Consultation Response from Alan Smith, KC Waste Strategy (Refuse & Recycling)
2025/91531 land off, Leeds Road, Heckmondwike, WF16 9DB
REVISED AND ADDITIONAL INFORMATION RECEIVED, AND REVISED DESCRIPTION: Demolition of existing semi-detached houses and associated buildings, and construction of 49 dwellings, including associated access and other associated works
Date Responded: 30/03/2026 Responding Officer: Alan Smith Responding Ref: WPN 26 015

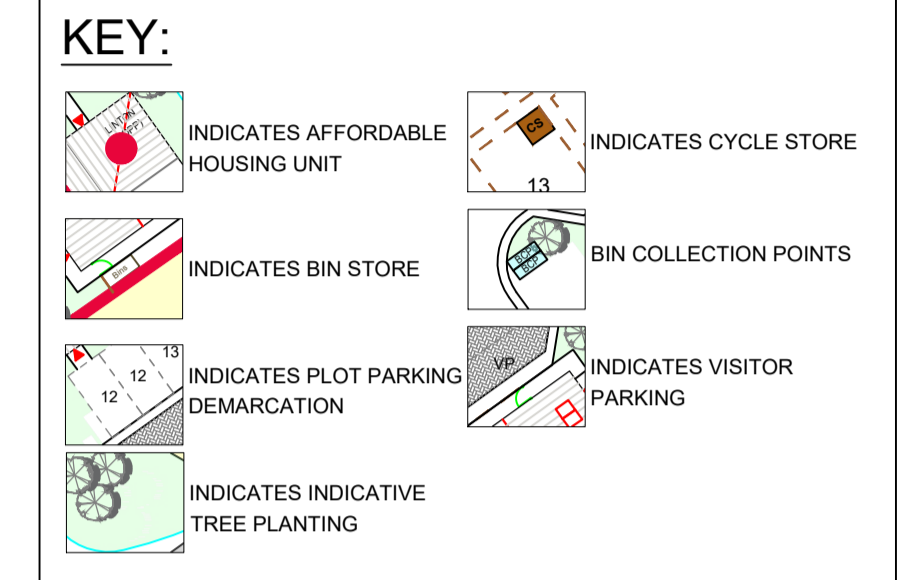
- Plots 12, 15, 28, 33, 38, 45 and 48 have a long convoluted route from the back garden to the BCP. The concern is that the resident will leave their bins at the front of their property. The developer should consider providing suitable bin stores at the front of the property that can hold 3 x 240 L wheeled bins and be also at least 2.5 m away from windows and doors.

- Plots 32, 33, 34, 35 and 36 – these properties have steps between the bin storage areas and the BCP which is not acceptable. The concern is that the resident will leave their bins at the front of their property. The developer should consider providing suitable bin stores at the front of the property that can hold 3 x 240 L wheeled bins and be also at least 2.5 m away from windows and doors.
